Ref : AB/118/20/PL
Proposed development at 70a Tarrant street. BN18 9DN

I am writing to object to the proposed development. My objections are as follows:

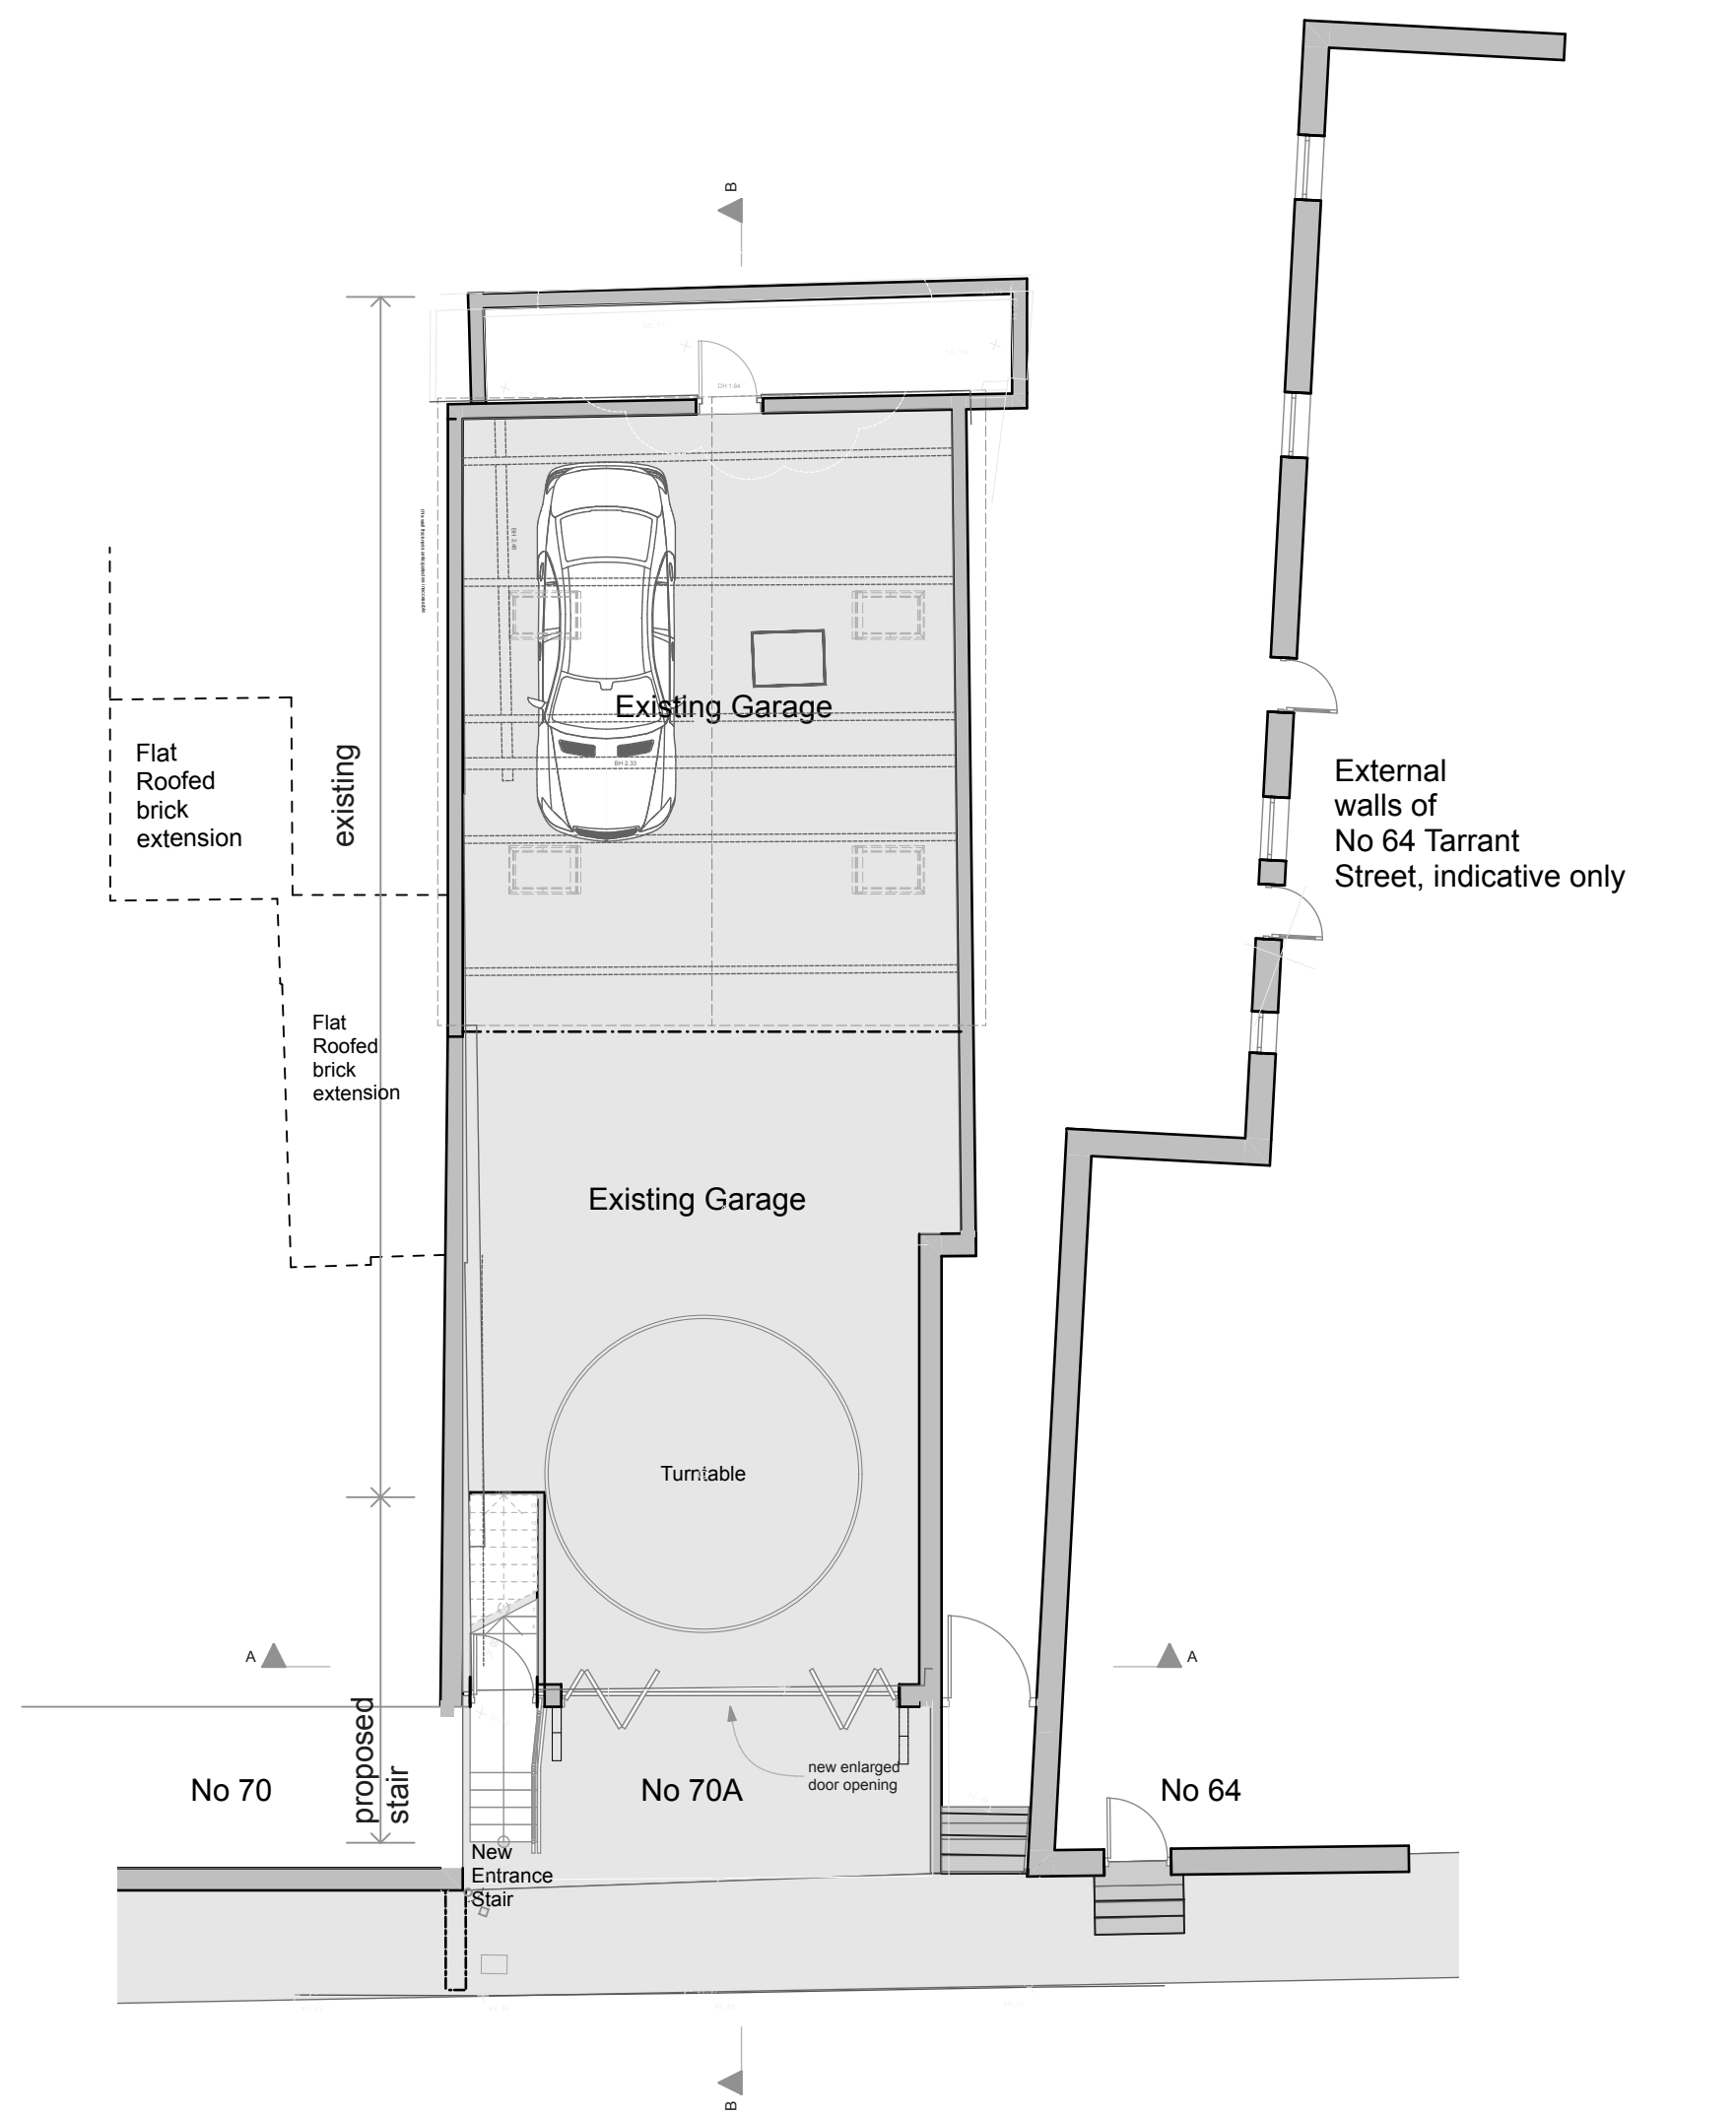
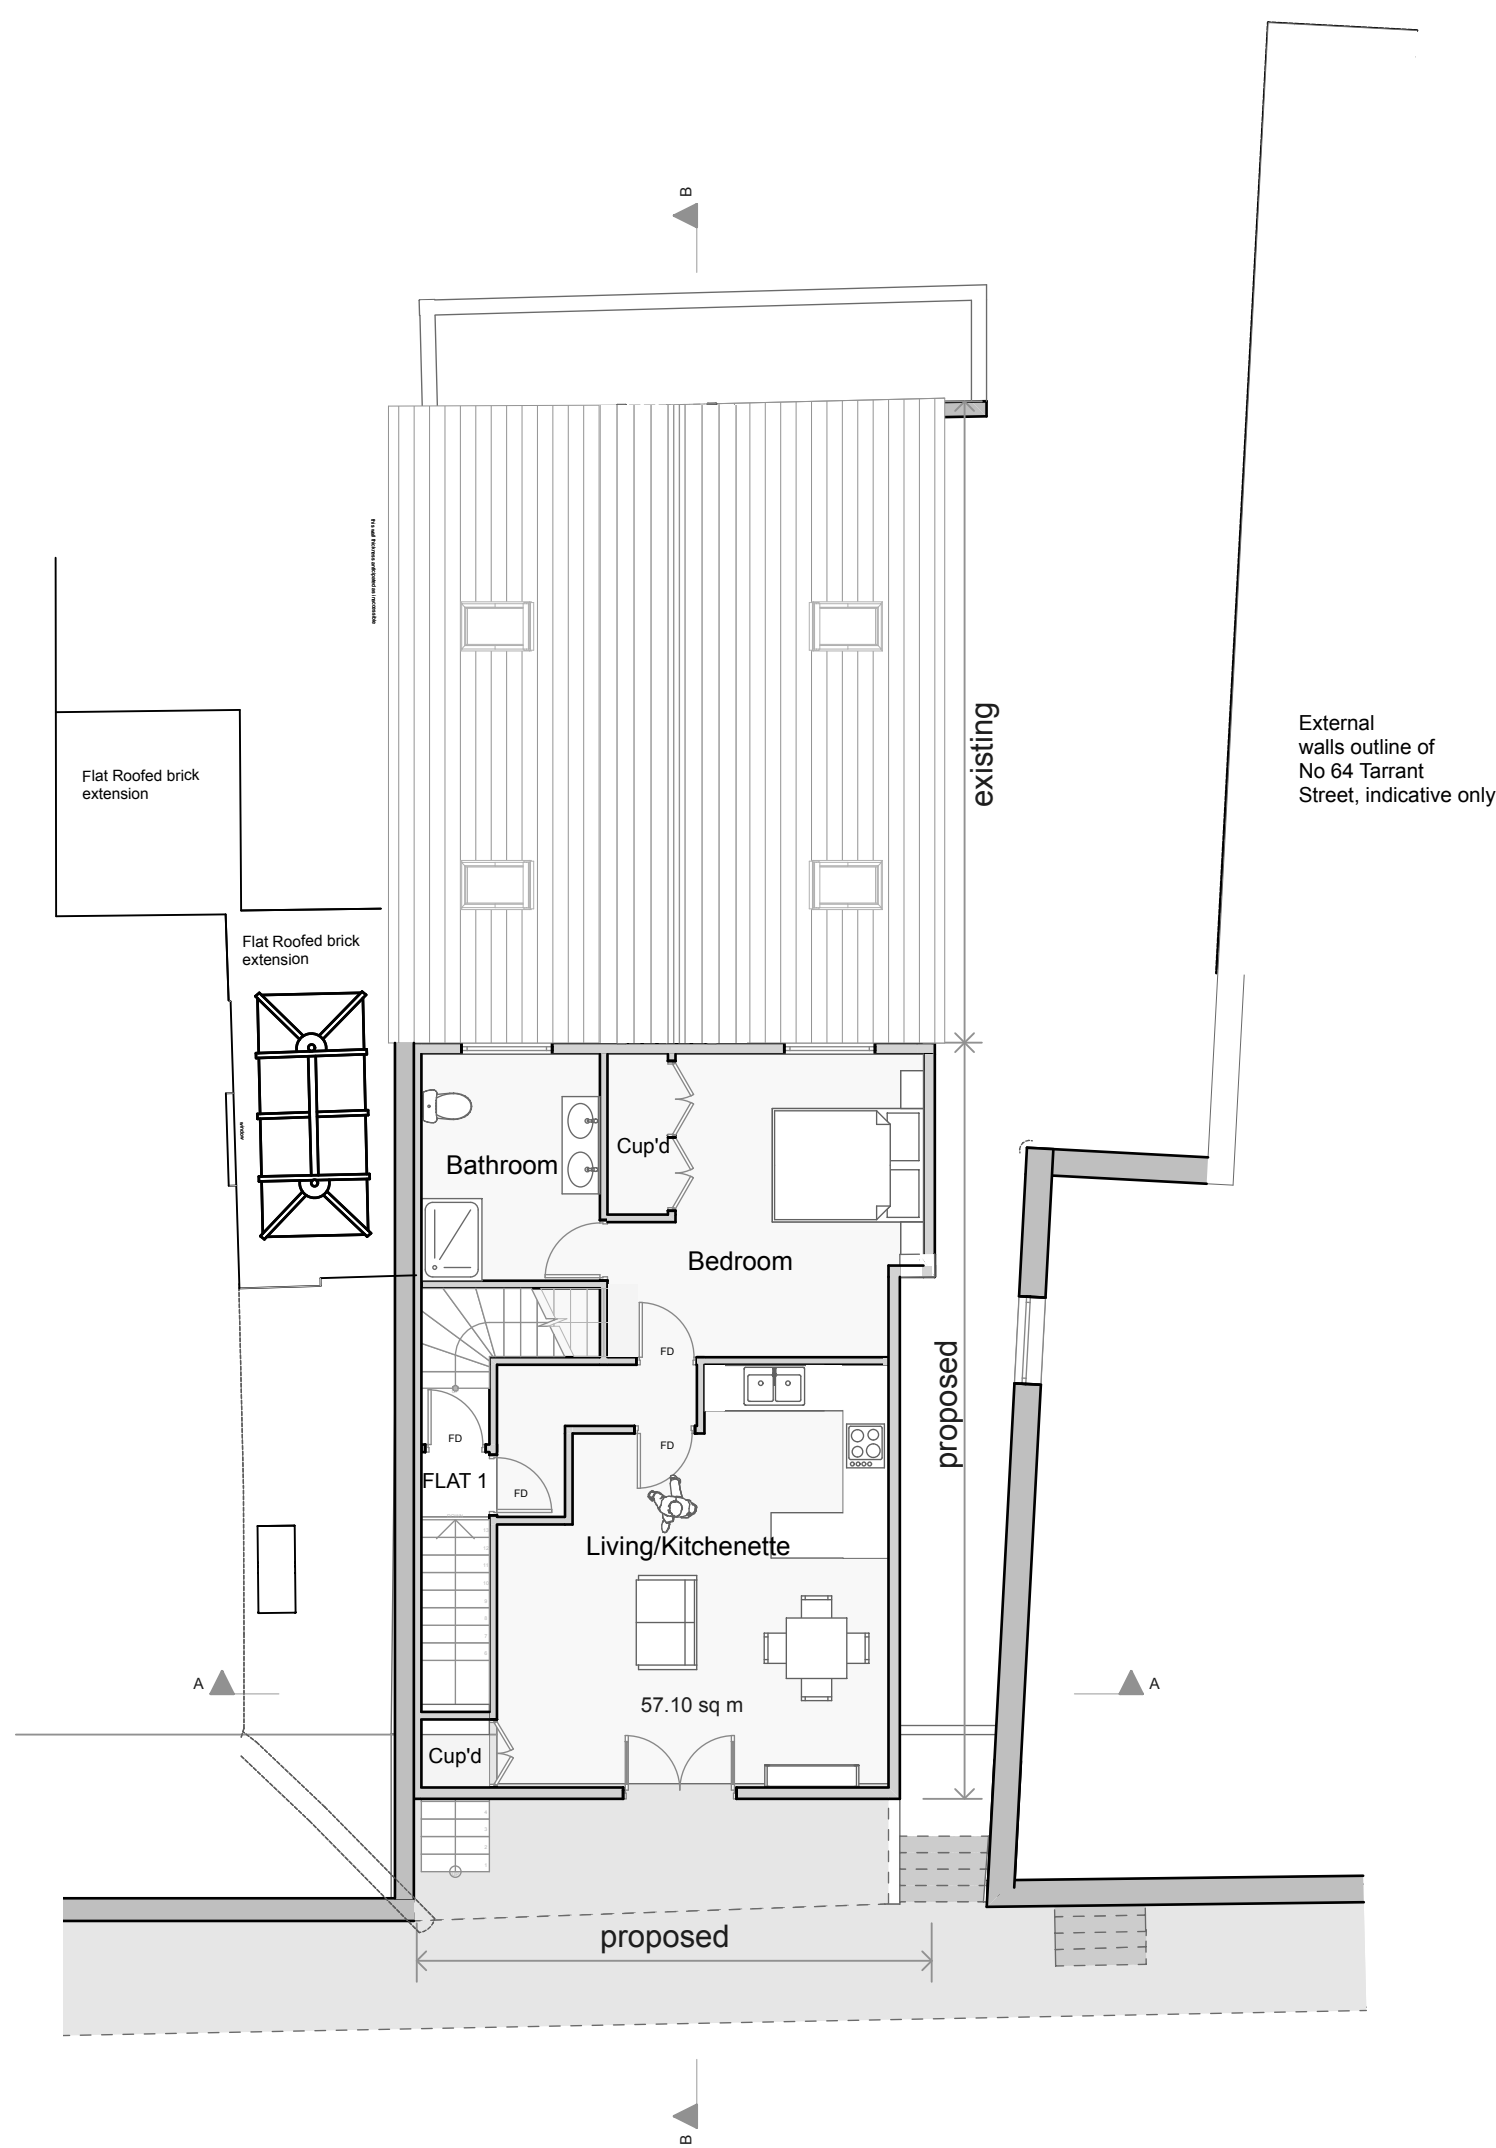
Incomplete and incomprehensible plans. There is no scale on the plans and no benchmark making it impossible to ascertain the height of the roof and the distances and measurements of the building. In the Wightman statement contained in the Application the photograph of the flank wall of 64 Tarrant st. does not show the four existing windows giving the impression that there will be no ill effect from the construction when in fact a huge percentage of light will be lost to the windows of 64 by the erection of a wall four feet from the flank wall, up to the roof line. There is also no indication of windows overlooking 70 Tarrant st when the developer himself has told me that there will be overlooking windows. This gives a distorted impression of the negative impact on both 70 and 64 that the new development will have. Juliet balconies are not in keeping with current architecture and do not improve the existing street scene. The large windows when open will create additional noise from the inside of these flats and cause loss of privacy to the houses on the south side of Tarrant street.
